Application number 2023/62/91768/W. Erection of 2 dwellings. Land off Netherley Drive, Marsden, Huddersfield, HD7 6HL

I wish to **object** to planning 2023/62/91768/W for the following reasons:

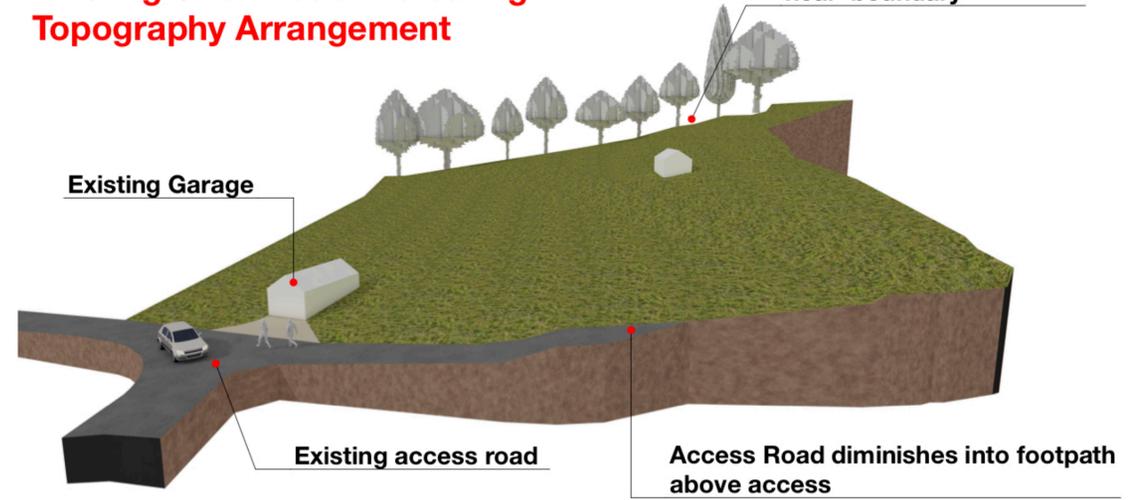
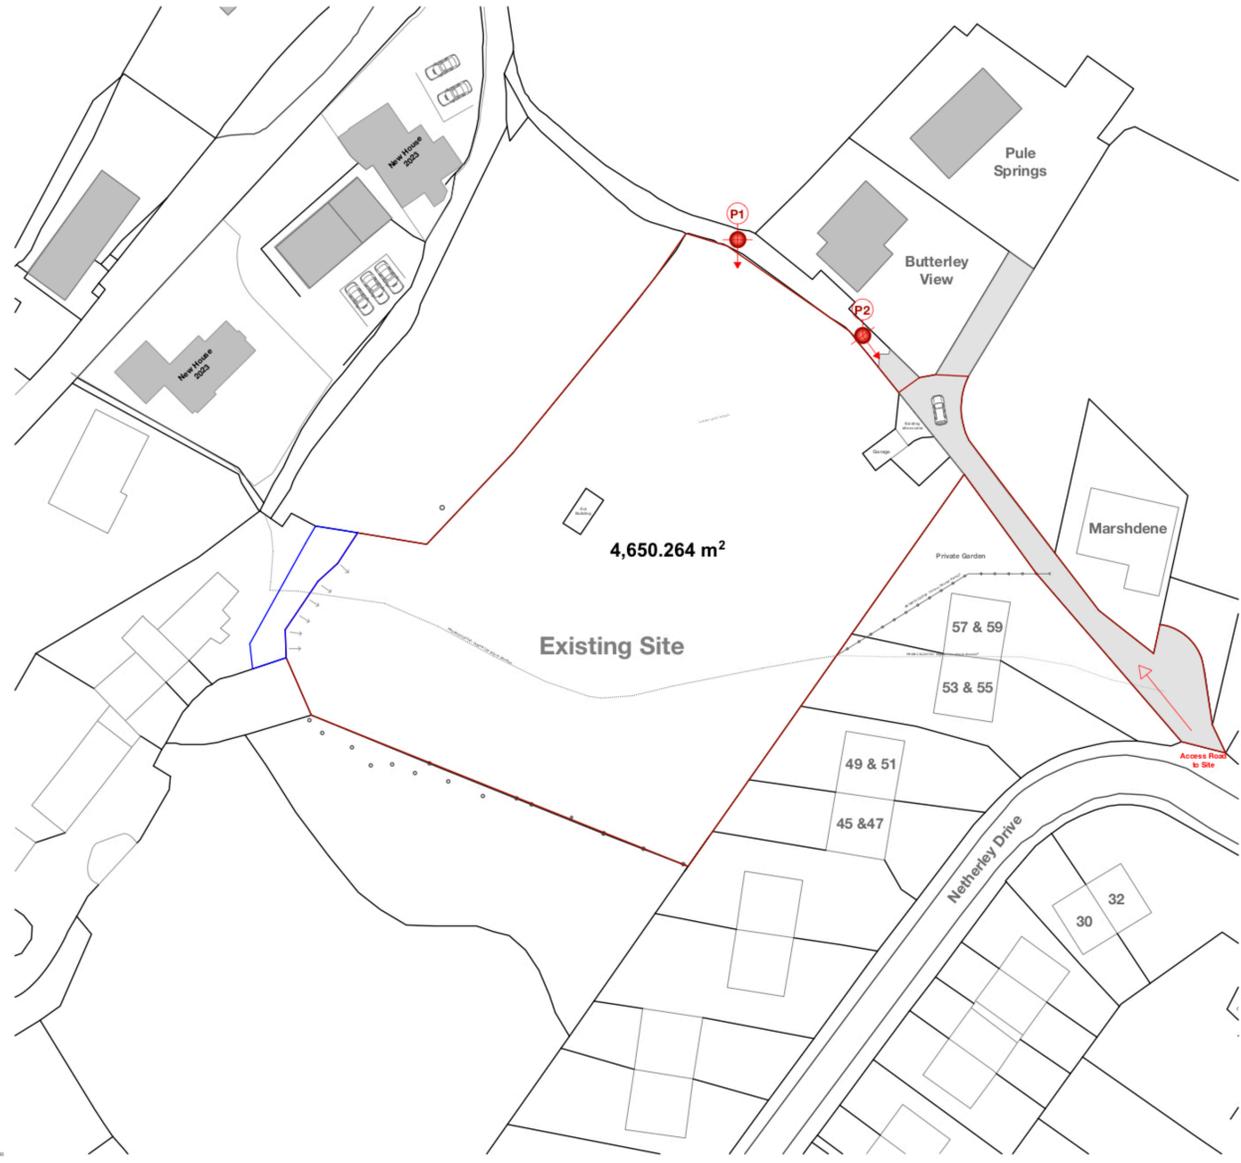
The extract below shows the route of public footpath COL/207/50 which traverses through the site. The planning layout shown on application drawing A.01.02 rev A would divert this footpath onto the access road leading to Netherley Drive. This would further increase pedestrian movements on the 60m long shared access road and exacerbate unsafe conflict between vehicles and pedestrians on this route.

The access width is severely substandard for an access road serving 6 dwellings, particularly as it also is shared with footpath 207/60 and potentially also 207/50. Vehicles are unable to pass and would be in conflict with pedestrians.
